Application number: 2026/91063	
What is the application for?:	Re-instatement and repair of existing building including alterations to roof and
Address of the site or building:	382, Huddersfield Road, Mirfield, WF14 9DL
Postcode:

Type of comment: An objection	
Do you wish your comments to be published on the website anonymously?	Yes

Dear Sir/Madam, I wish to formally object to the planning application for 382 Huddersfield Road, Mirfield, WF14 9DL, for the following reasons:

Drawing Title:
Proposed Grouped Plans

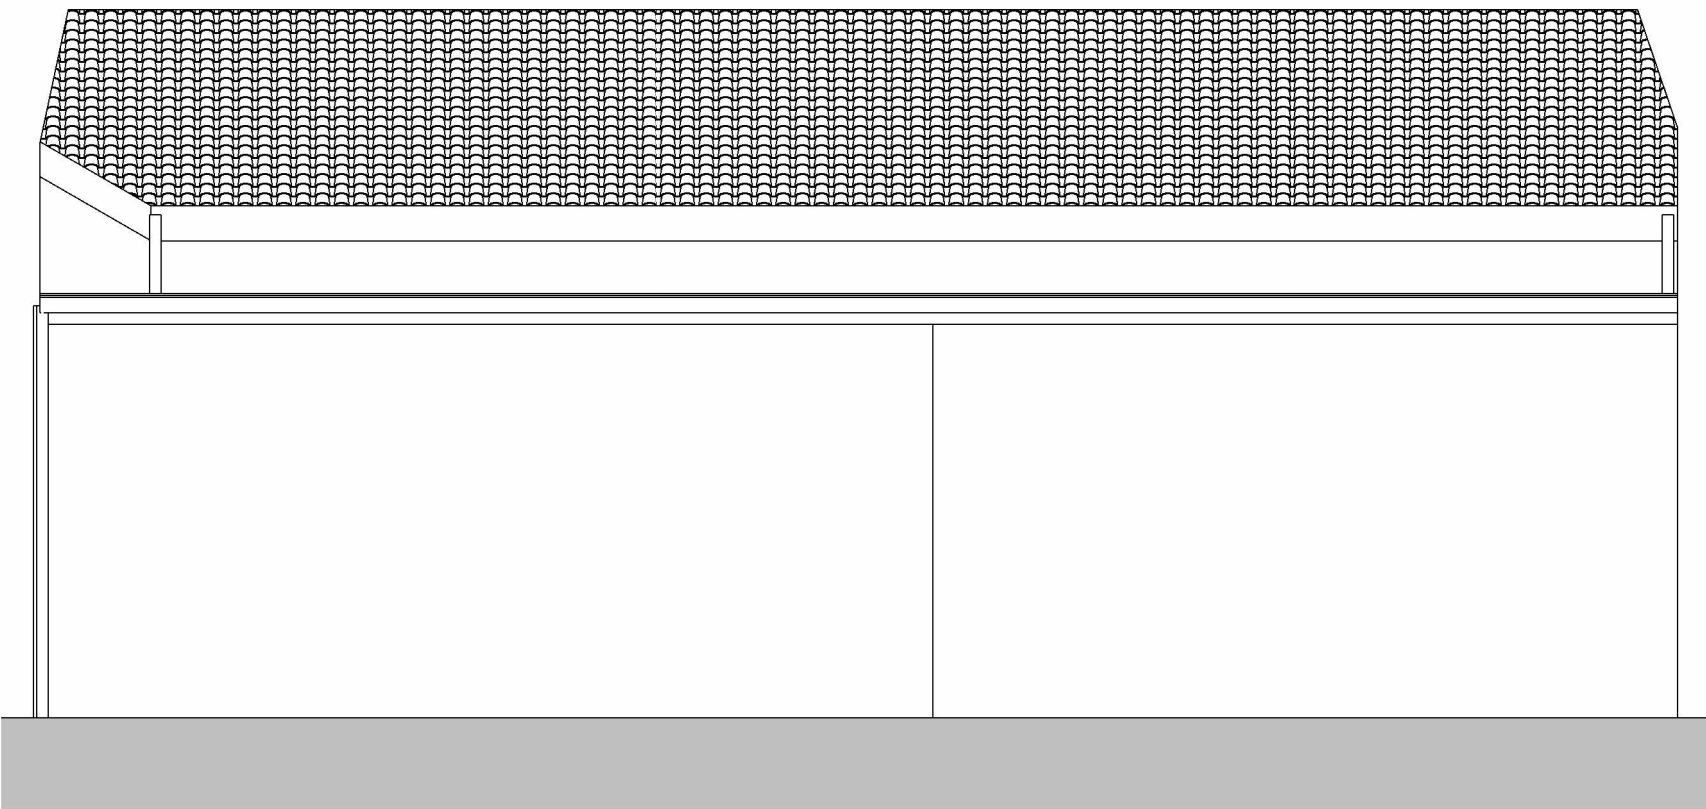
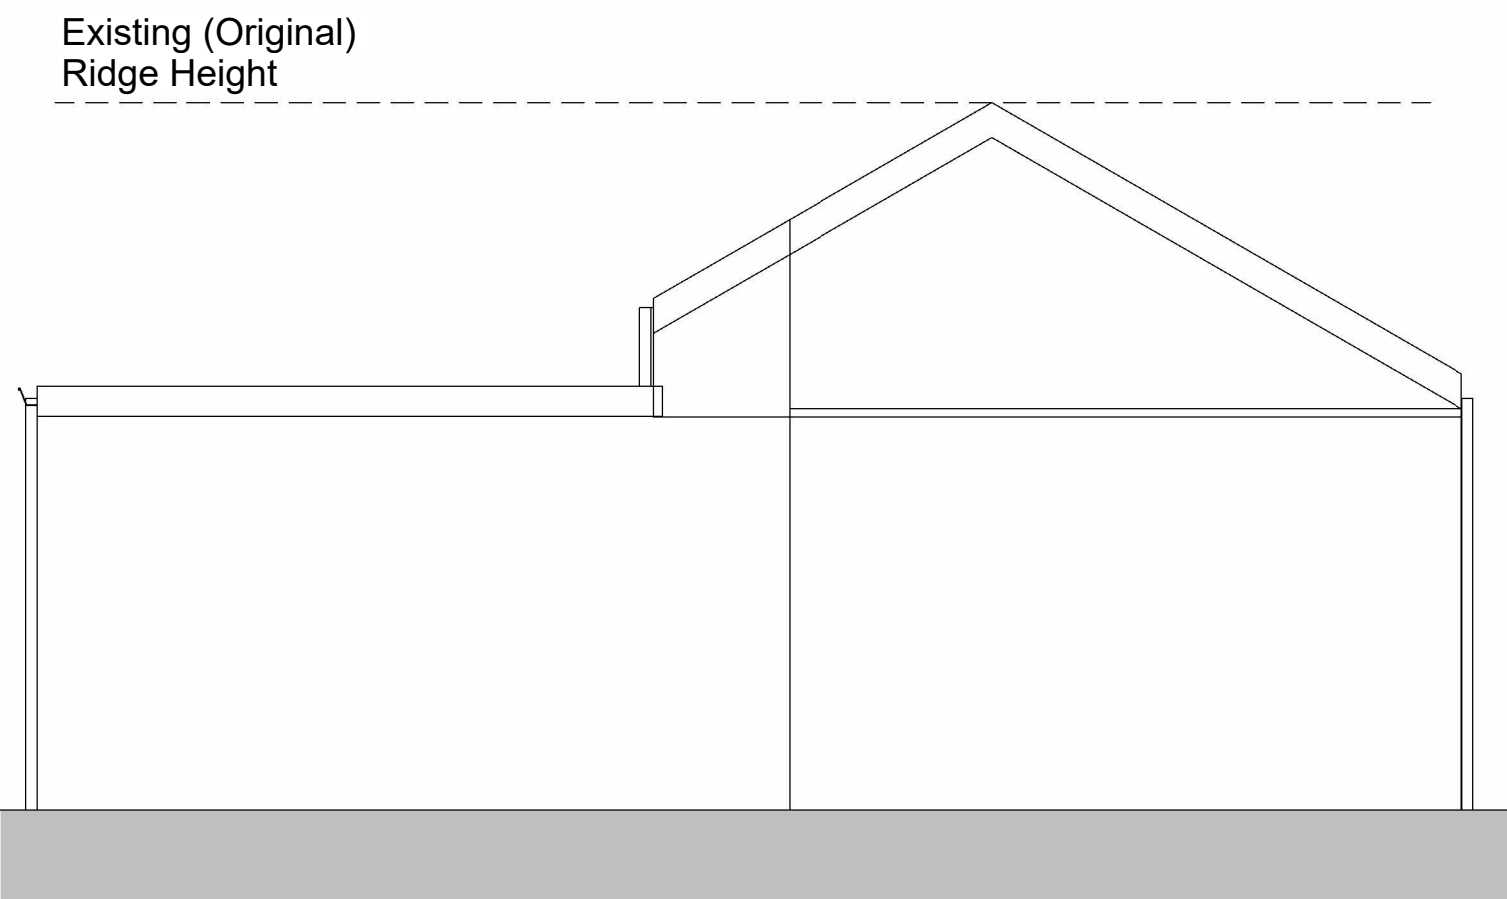
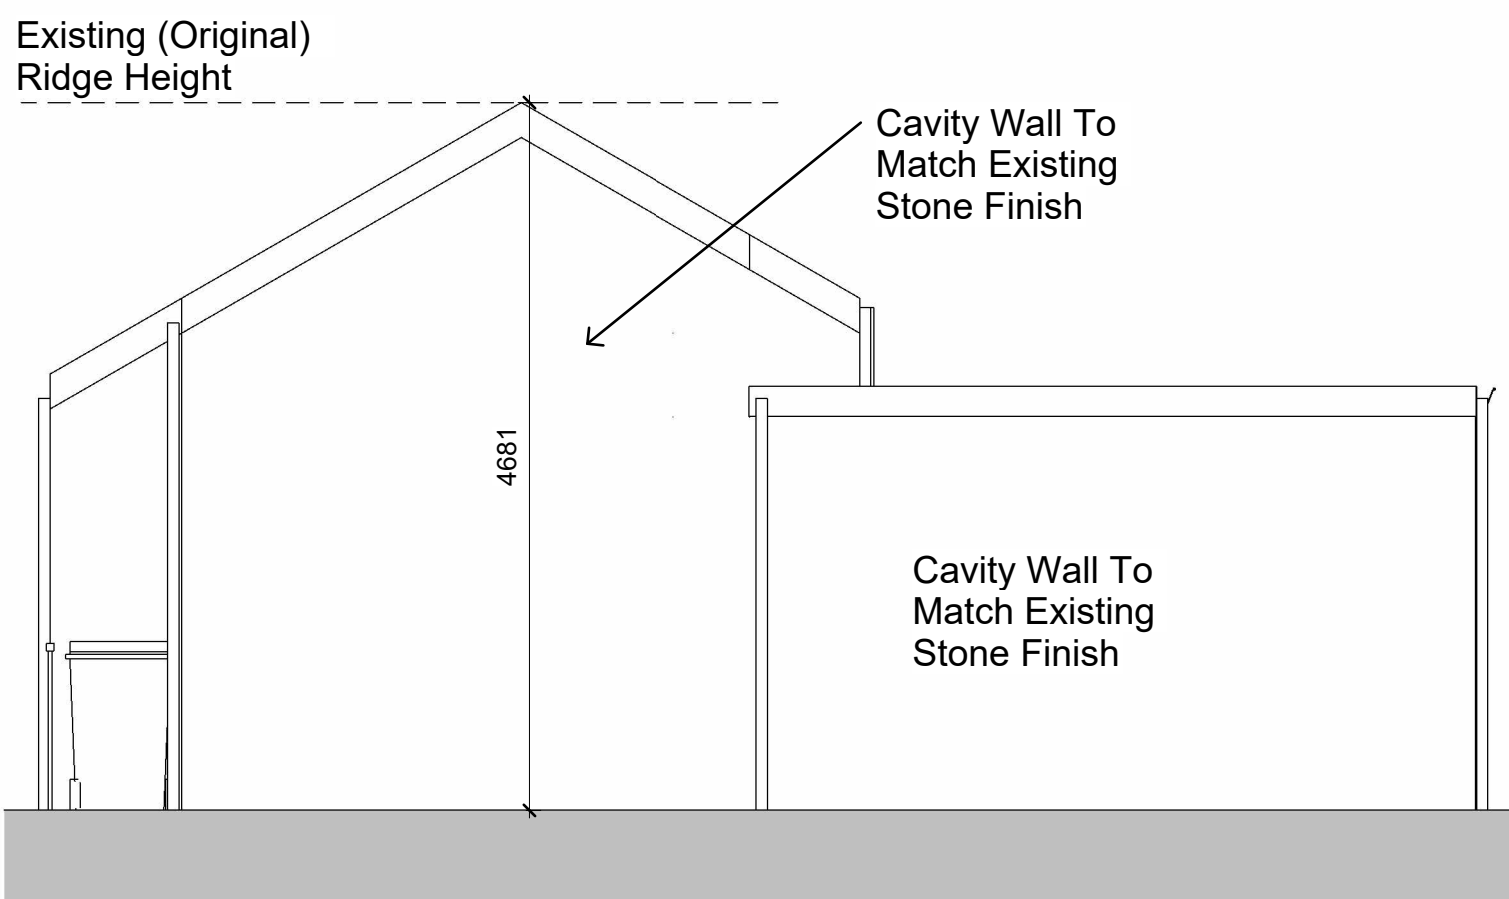
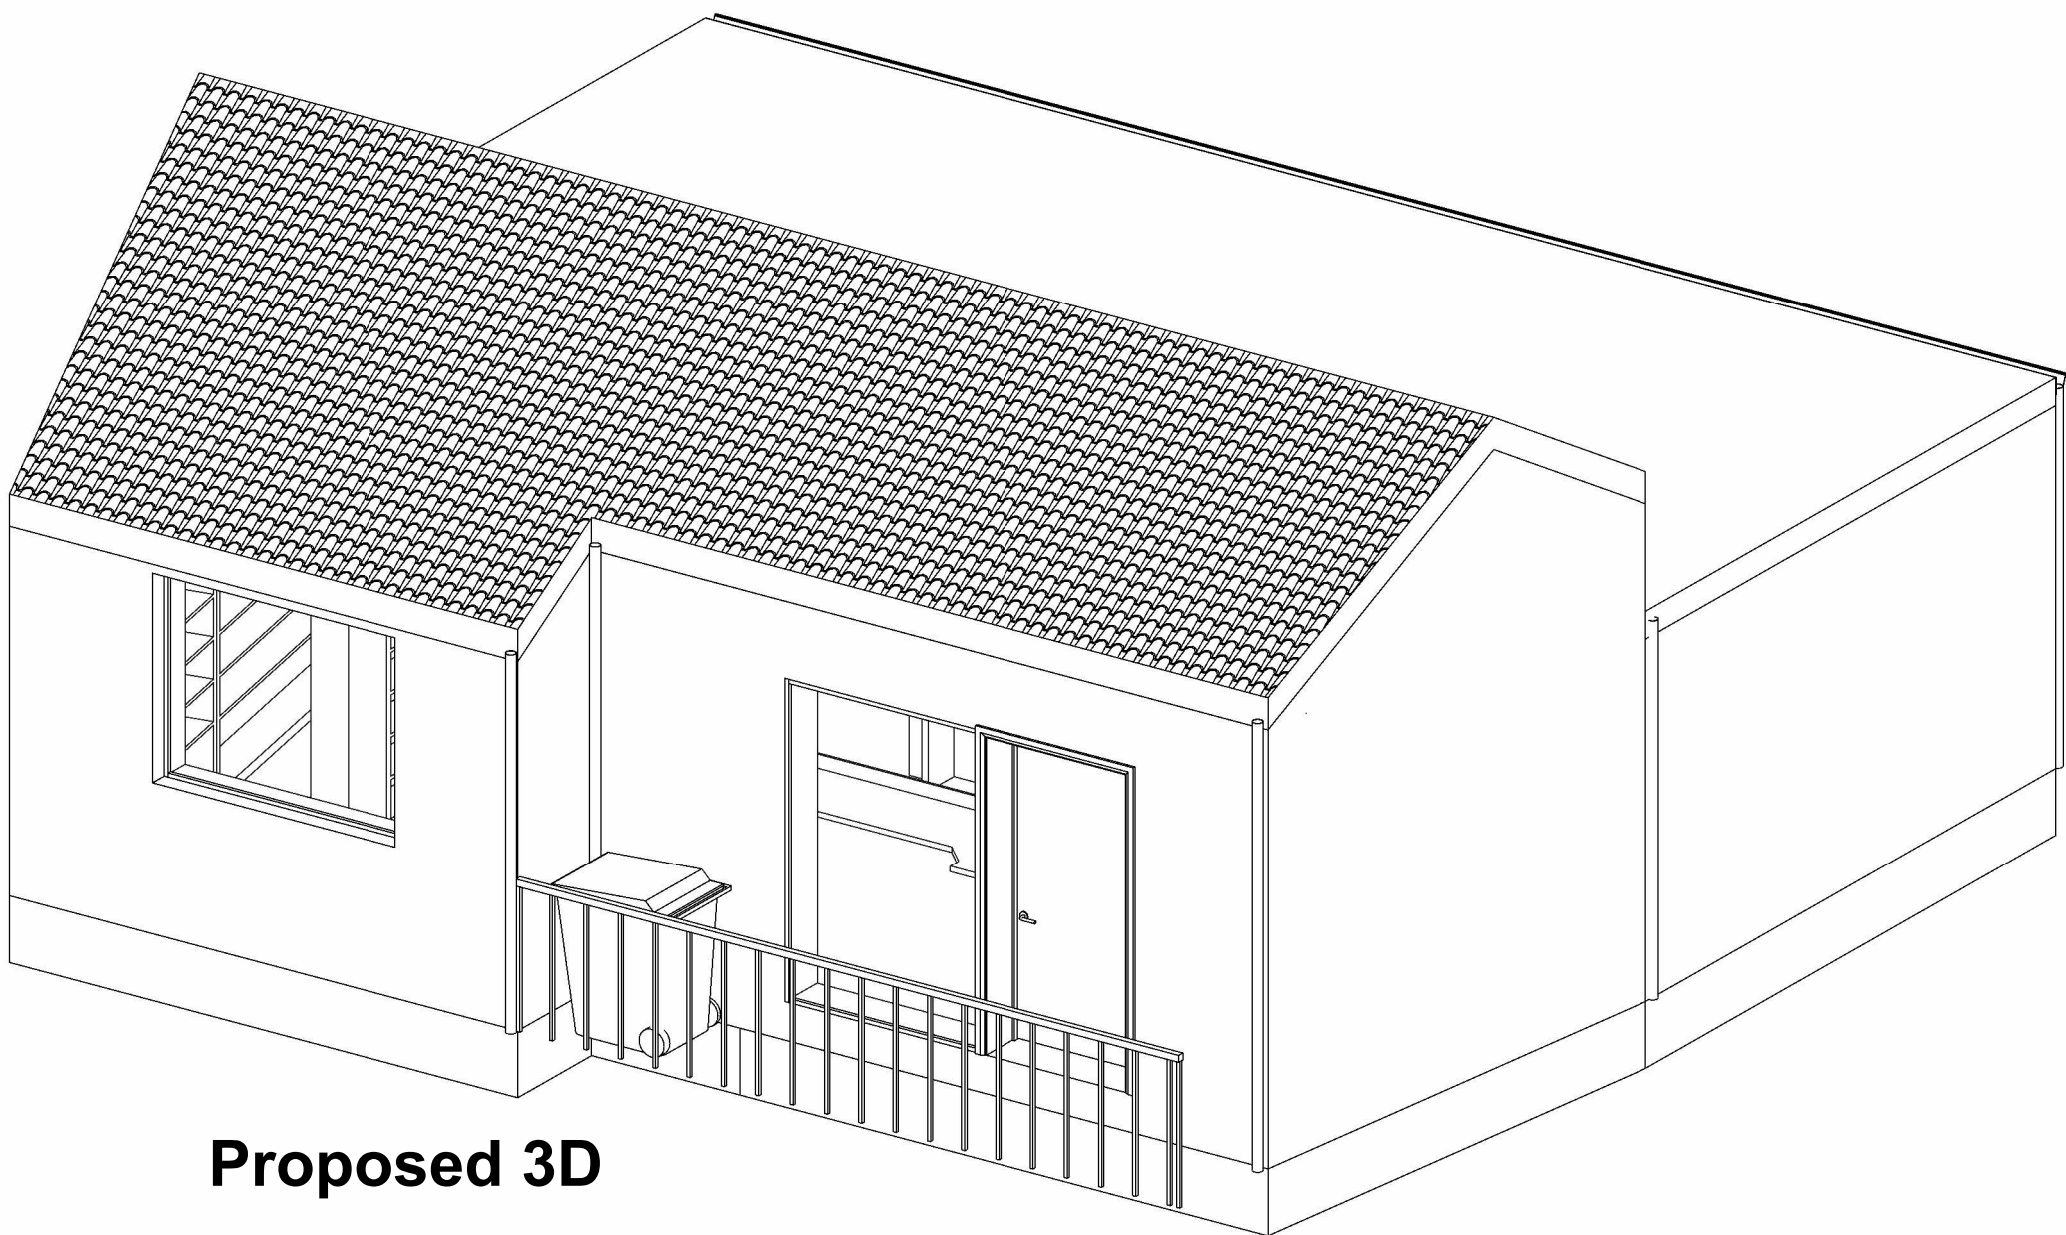
Inadequate plans: The submitted drawings do not accurately show the full nature, levels and scale of the development, particularly the subterranean rear elevation.

Accurate plans and sections are required before the application can properly be assessed.

Out-of-character design: The proposed dormer roof is excessive and out of keeping with the established character of Huddersfield Road. It would have a harmful visual impact and fails to properly respect the existing street scene, contrary to Kirklees Local Plan Policy LP24.
